Cllr Gary Cowan

WRITTEN REPRESENTATION

HIGHWAYS ENGLAND'S RESPONSE

Job Title	M4 JUNCTIONS 3 TO 12 SMART MOTORWAY
Drawing Title	WORKS PLAN REGULATIONS 5(2)(j) & 5(2)(p) SHEET 10 OF 31 WOKINGHAM
Drawing Number	TR010019 - 2.3

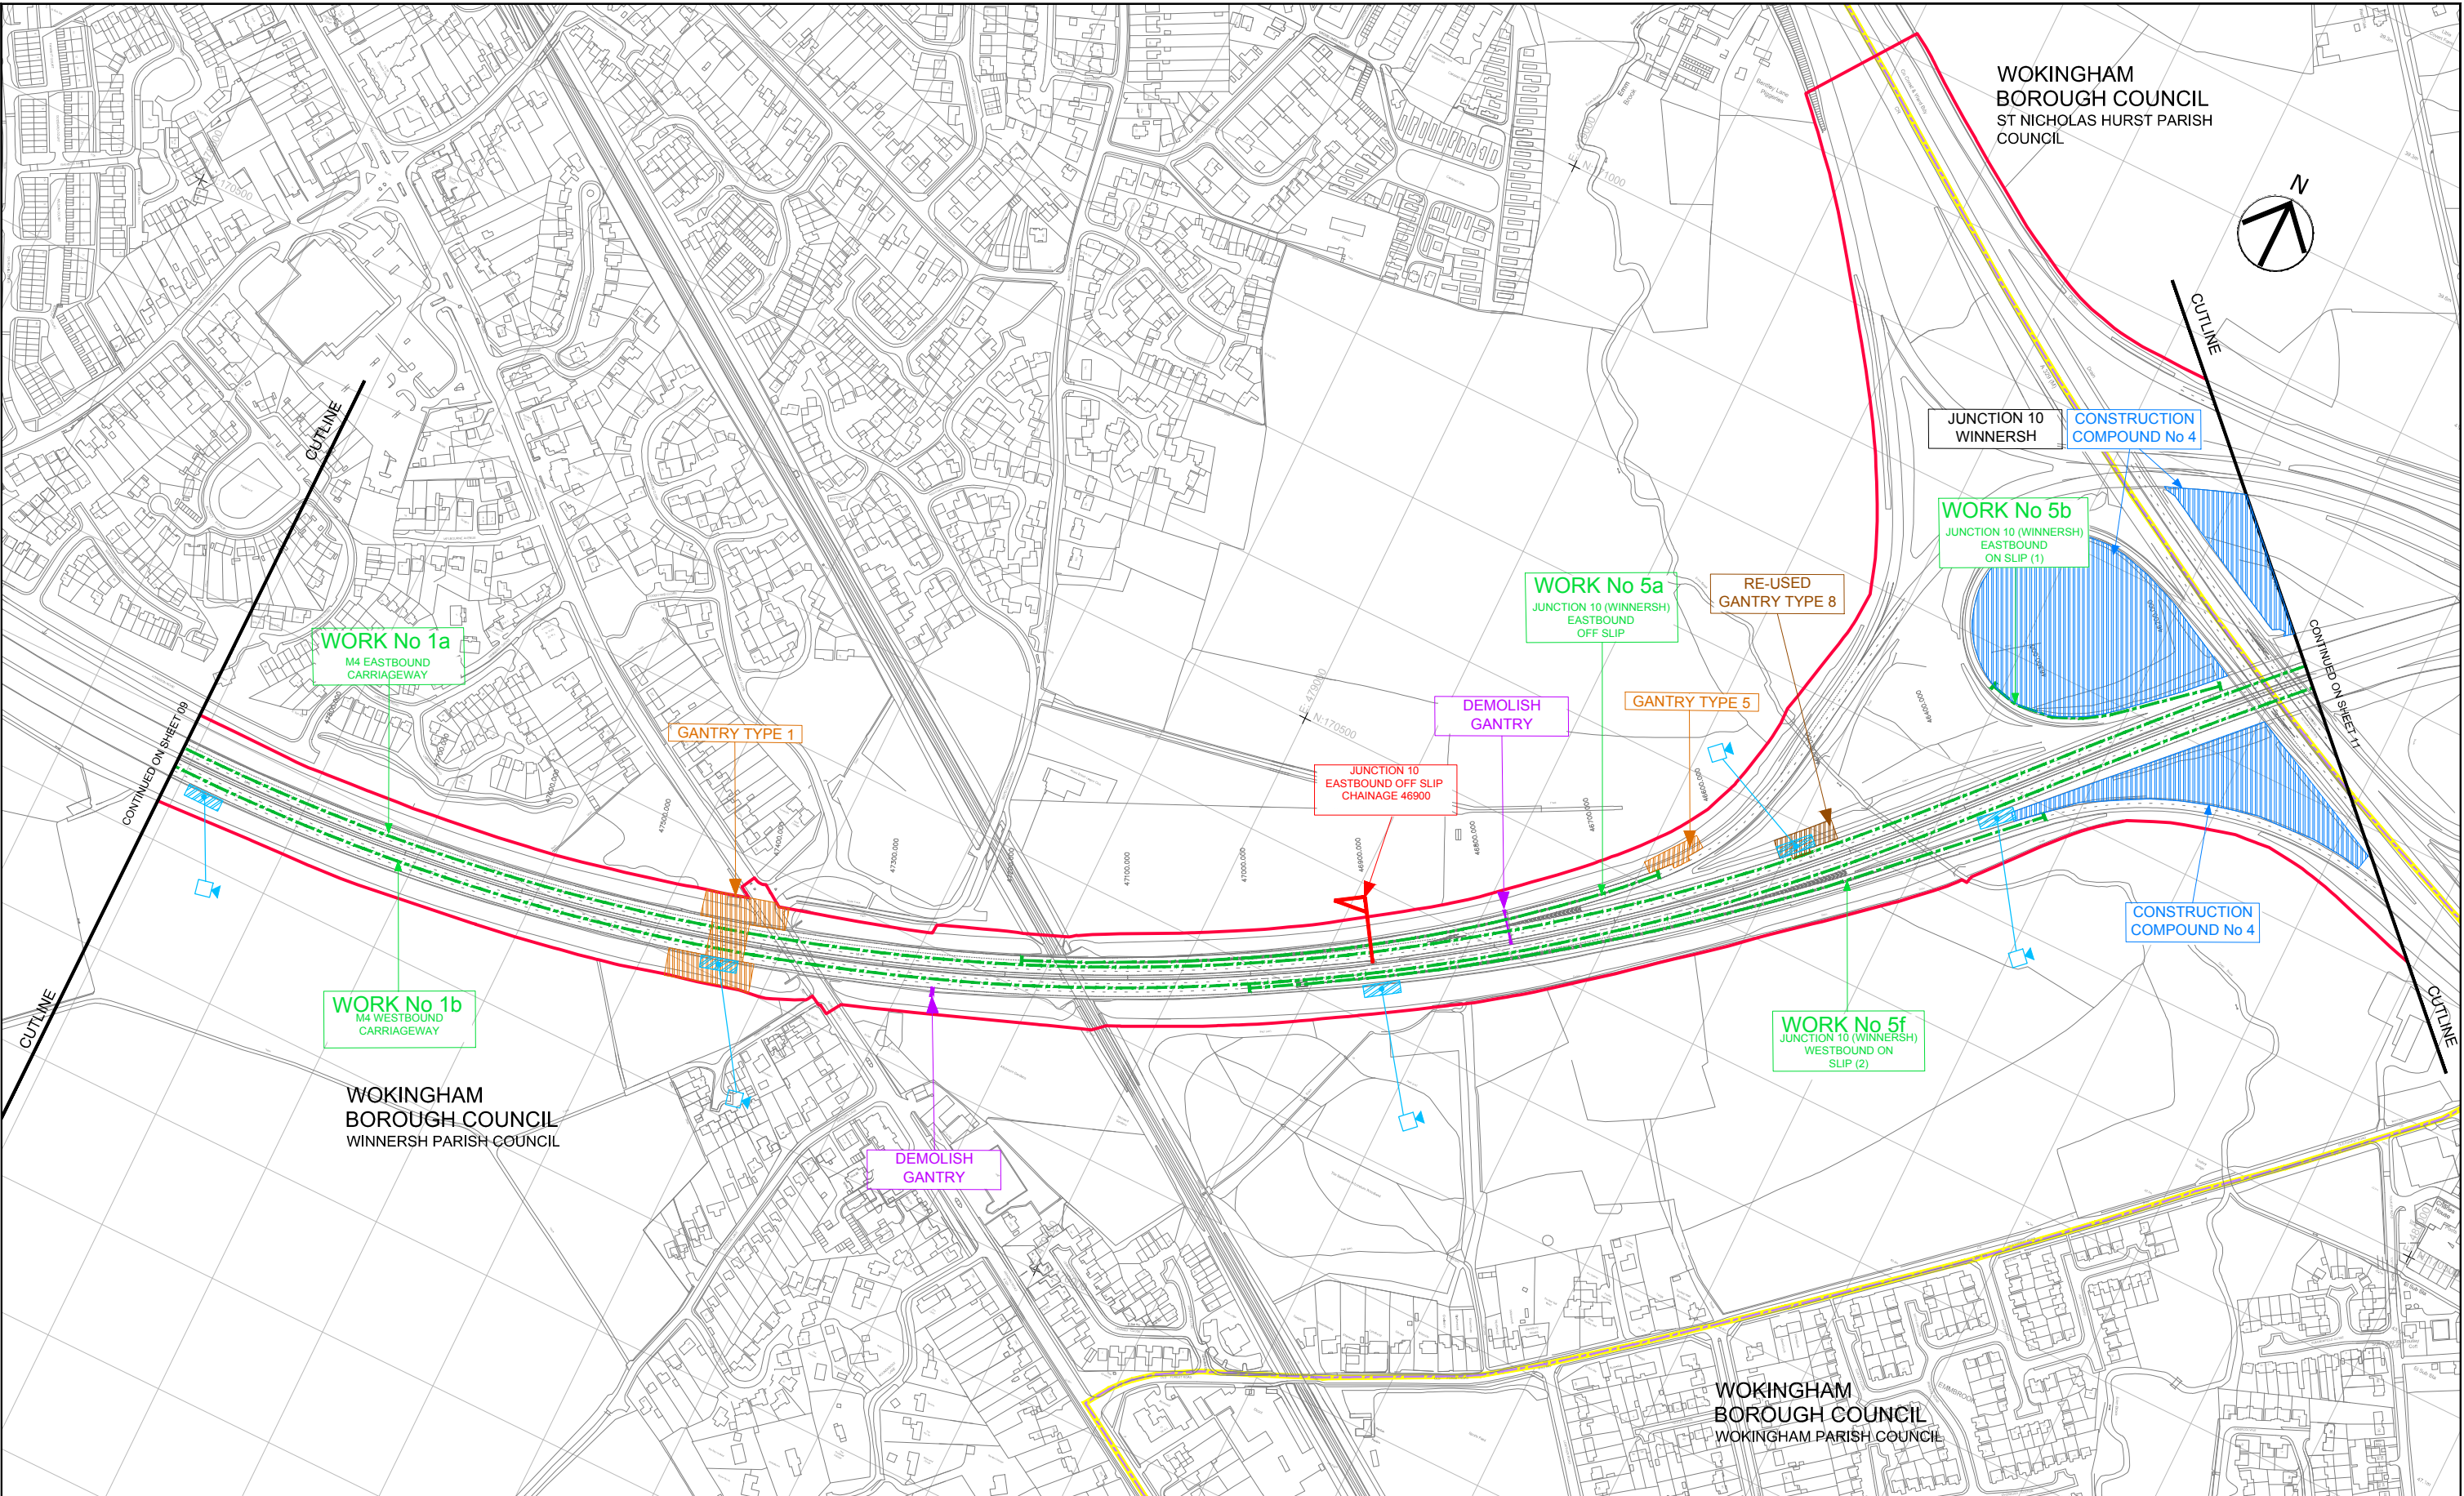
8. *The M4 Smart Motorway impact on local feeder roads does not seem to have been addressed from Junctions 10/11. I recognise the scheme is designed to increase the capacity and flow of traffic on the M4 which is very welcome but fails to deal with local traffic entering/exiting the M4 from the local feeder roads Traffic using the A329/329M getting to/from Reading, Woodley, Winnersh, Earley and Bracknell and vice versa are subject to long queues/delays at the A329M at peak times. This leads to inconvenience and pollution and need to be addressed within the overall scheme.*

- 8.1 The M4 junction 10 is the exit for the A329(M) leading to Wokingham, Bracknell and Reading (east). Work has recently (December 2015) been completed on an improvement scheme as part of the Pinch Point Programme. The changes to the layout of the junction have

been implemented to ease congestion and improve traffic flows from the M4 onto the A329(M). The works involved:

- 8.1.1 widening the north and southbound slip roads from the M4 onto the A329(M) to allow for new two lane merges;
 - 8.1.2 reducing both carriageways of the A329(M), where it crosses the M4, to one lane using road markings; and

- 8.1.3 amending the road markings on the link roads from the M4 eastbound carriageway to the A329(M) Wokingham bound carriageway to allow for two lanes.

- 8.3 As the project has only recently been brought into operation, Highways England is closely monitoring its operation.
- 8.4 The traffic forecasts for the M4 smart motorway Scheme have also included traffic associated with the planned developments included within the Wokingham core strategy. Highways England and Wokingham Borough Council have been sharing information from their respective traffic models to ensure proper account is taken of the various development and associated infrastructure proposals.
